Objection to planning application 2021/92462

Land to rear of 1091 Manchester Road, Linthwaite, Huddersfield HD7 5LS

STATUS			PROVISIONAL		
PROJECT			LAND OFF 1091 MANCHESTER ROAD		
TITLE			PROPOSED		
CLIENT			P.WHITING		
DRAWN BY	CHECKED BY	DATE			
Author	Checker	12.05.2021			
SCALE (@ A1)		PROJECT NUMBER			
As indicated		HD.20.33			
DRAWING NUMBER				REV	
HD.20.33.01

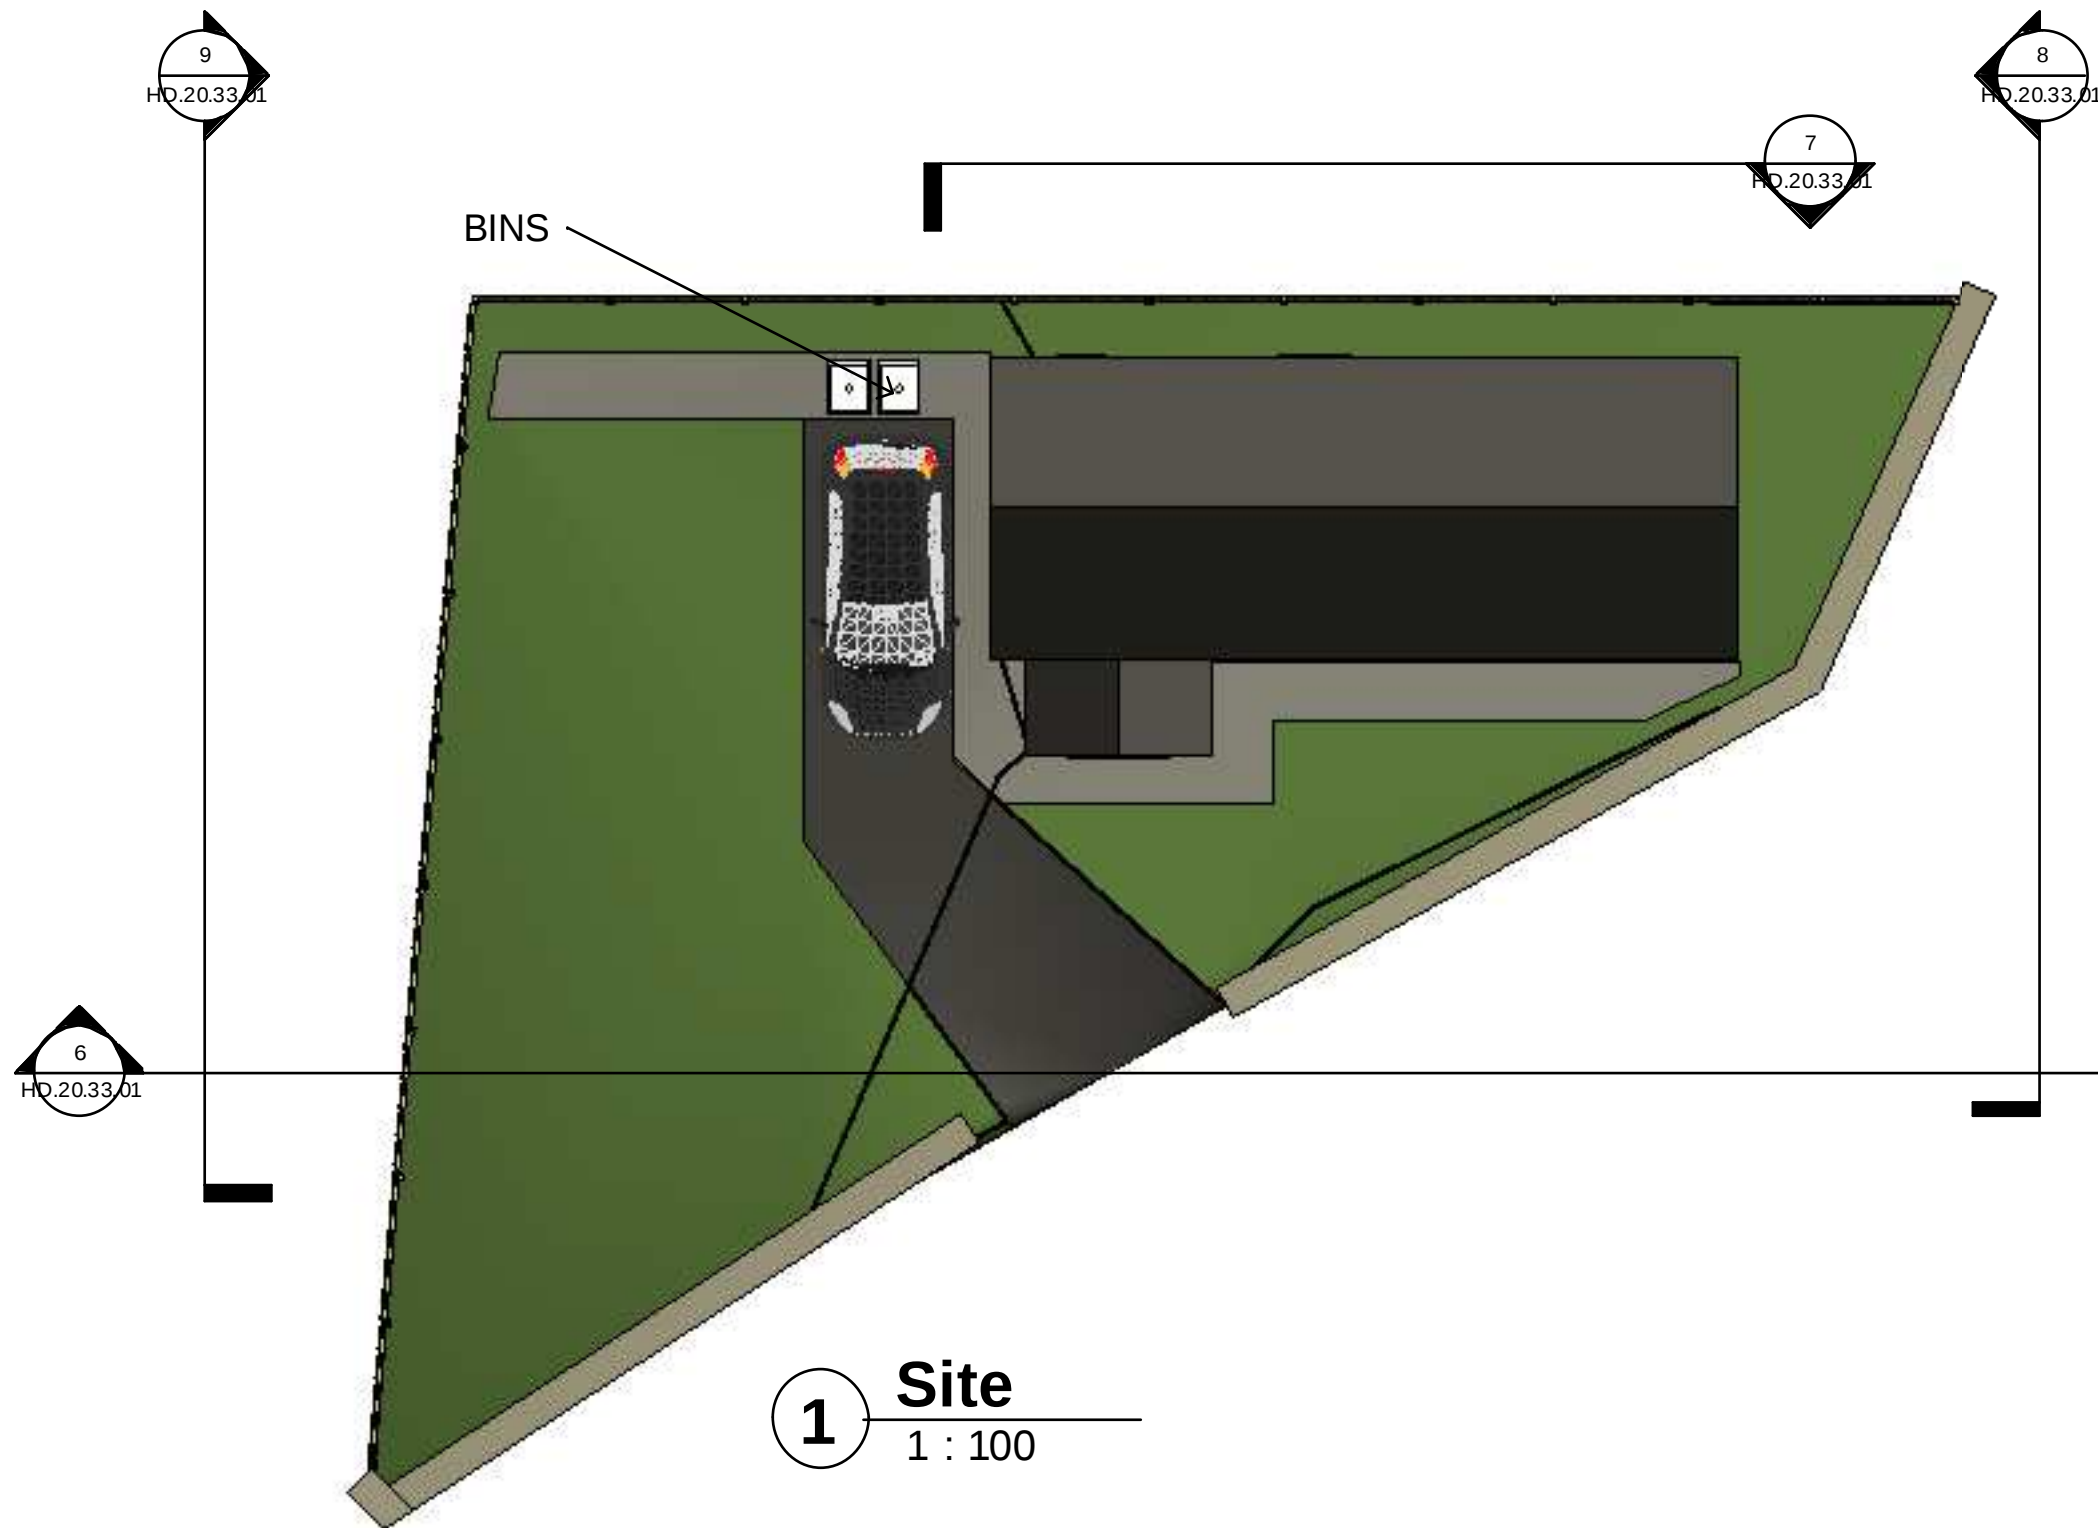
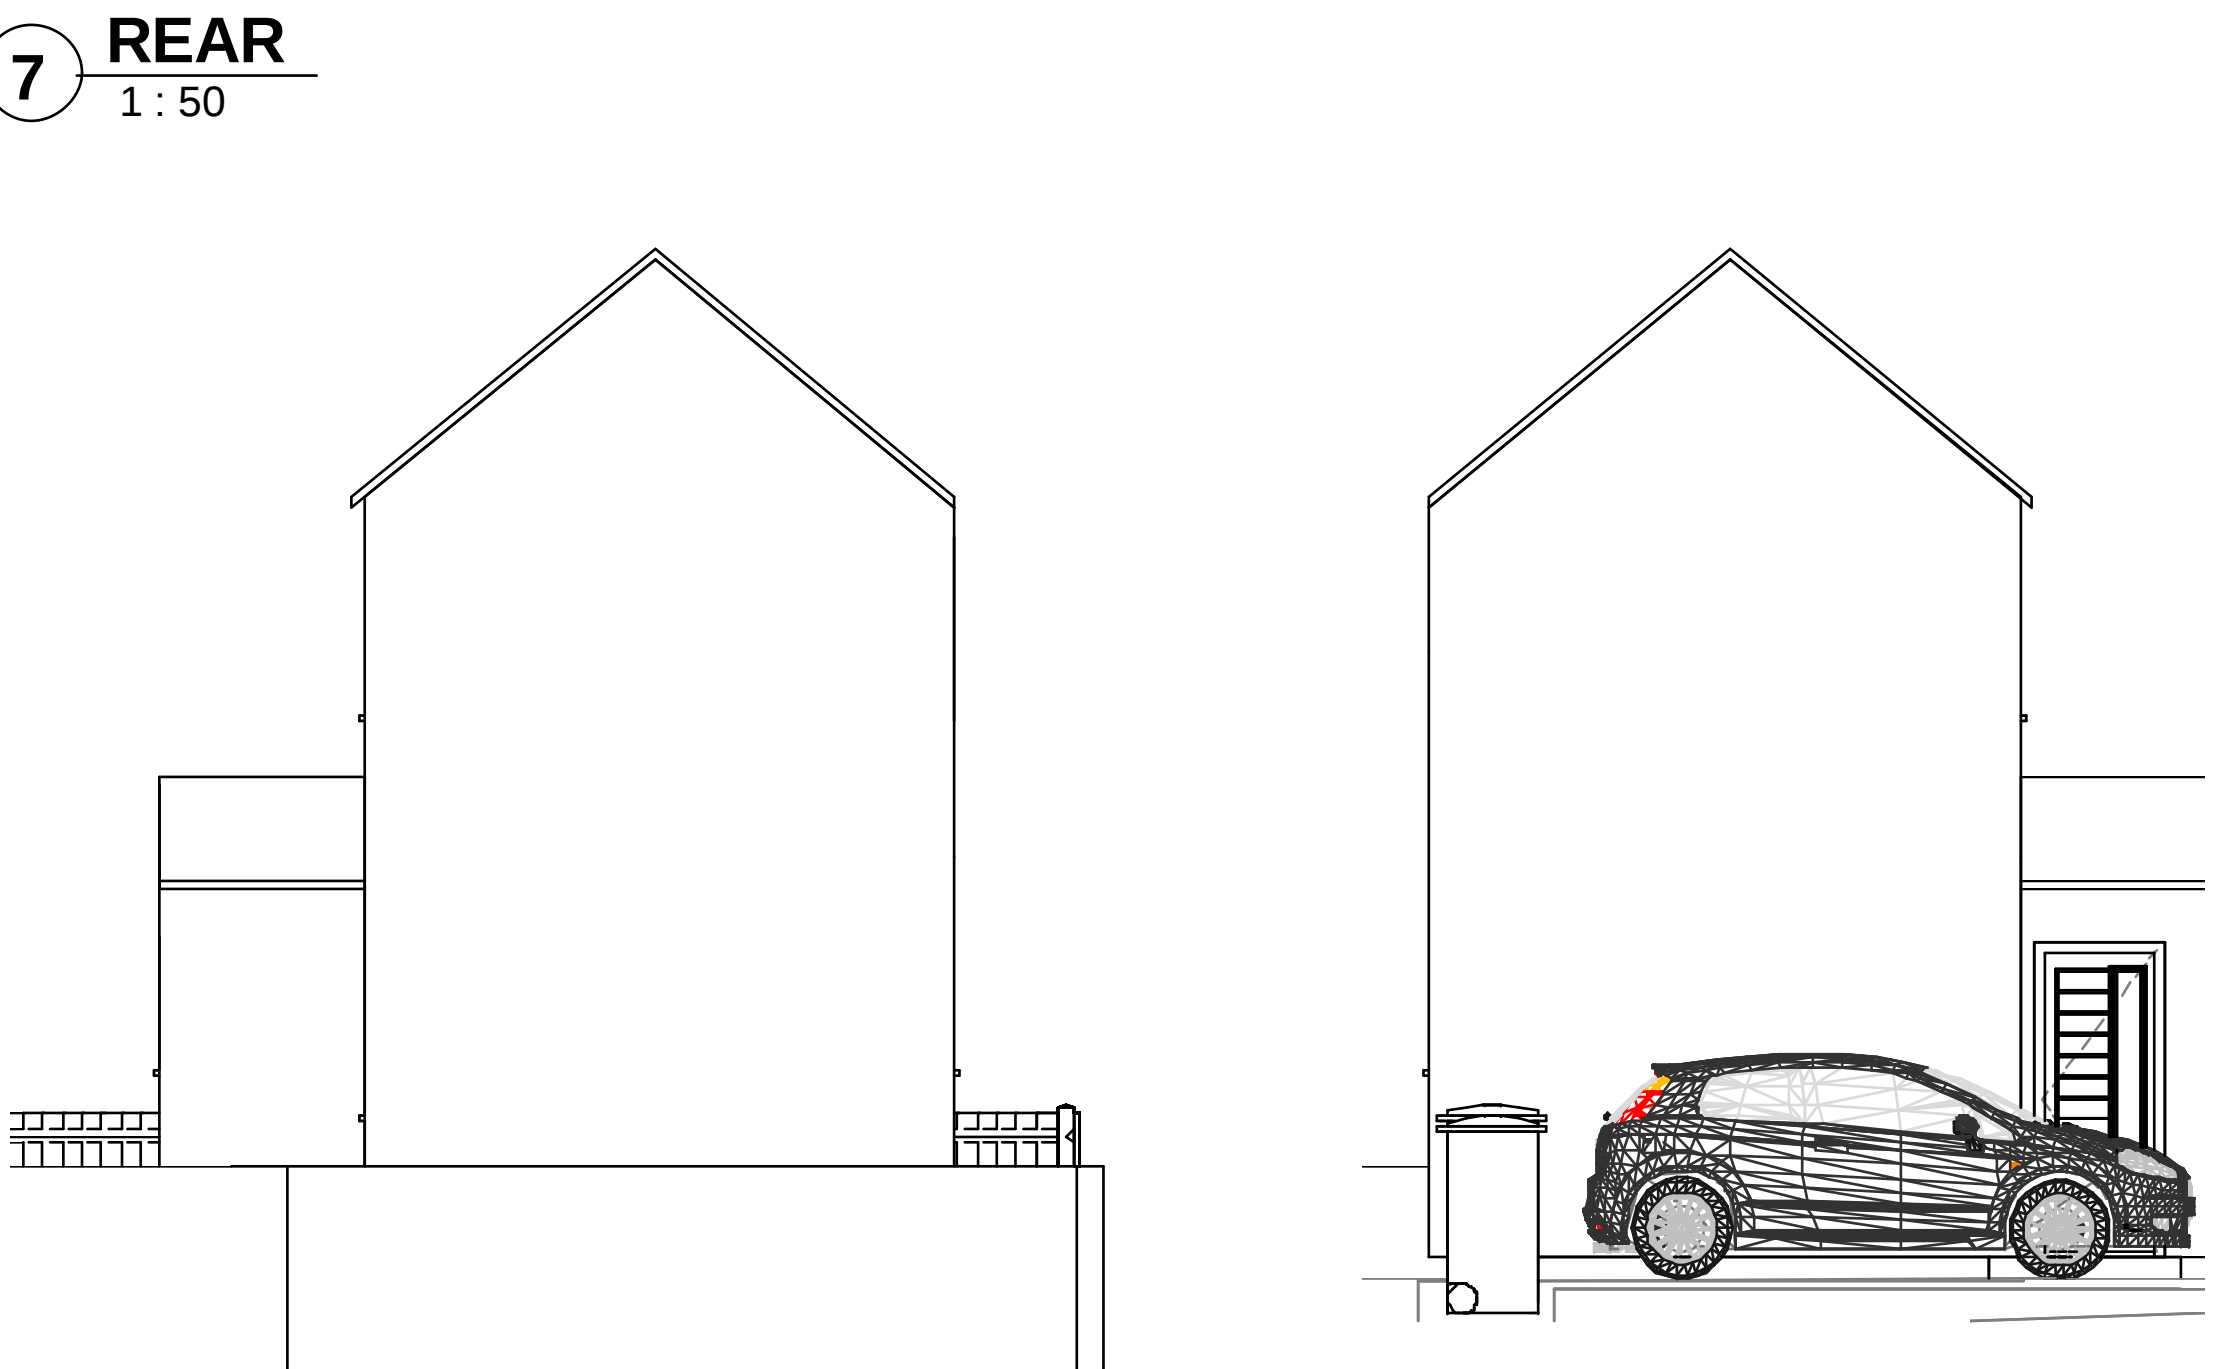
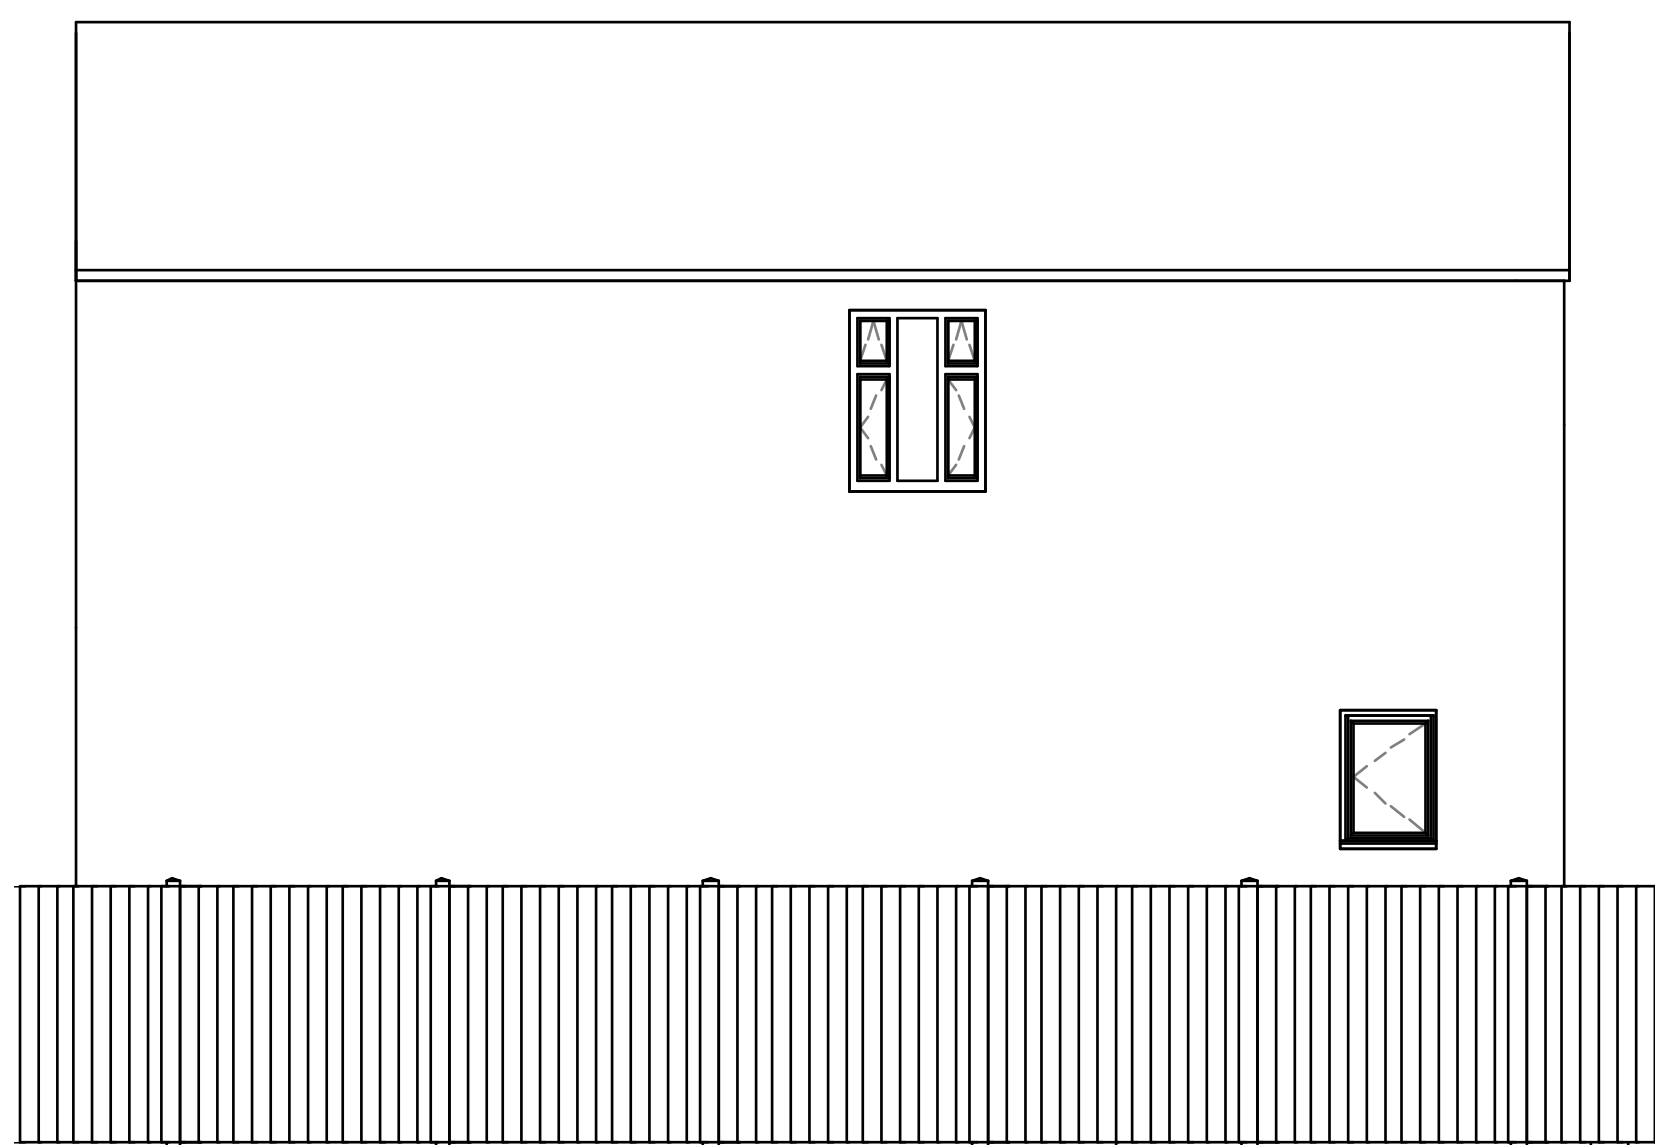
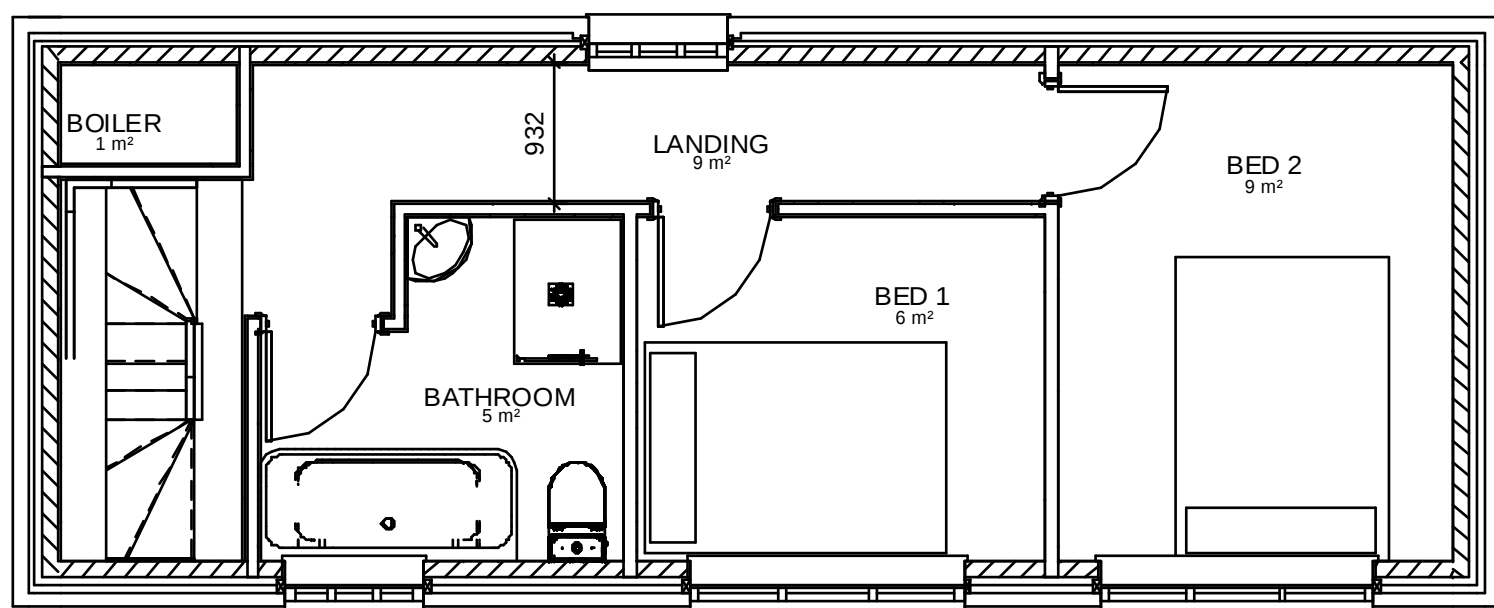
Firstly the proposed development is a 2 bedroomed build and not a 3 bedroomed one as stated in this assessment.

Albeit that it is suggested to use stone and slate in the new build, the actual placements of the windows in the proposed build do not reflect the weavers cottage style of its surroundings.
